Application # 0750017983R

COUNTY OF HARNETT LAND USE APPLICATION

**RE: Harnett County Land Use Application HTE# 07-5-17983 Lt#254 Crestview Est.
THE# 07-5-17982 Lt#253 Crestview Est.**

SILVERADO HOMES, LLC.
 THE STUART
 LOT # 254 CRESTVIEW
 SCALE: 1"=50'
 40

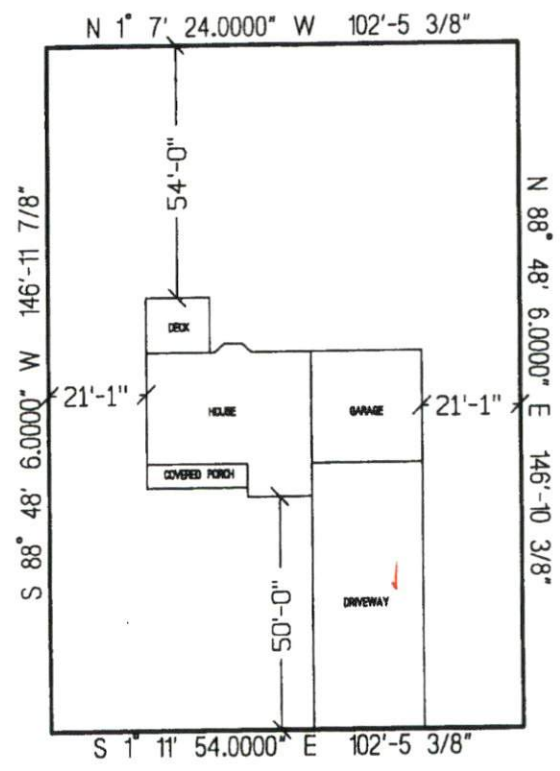
- 1. Property lines/corners not marked or labeled
- 2. House corners not marked or labeled
- 3. Directions not clear to property
- 4. Property needs brush or vegetation removed
- 5. Backhoe pits required
- 6. Other *Please move house location as shown on attached sheet and submit new plot plan with changes to Central Permitting.*
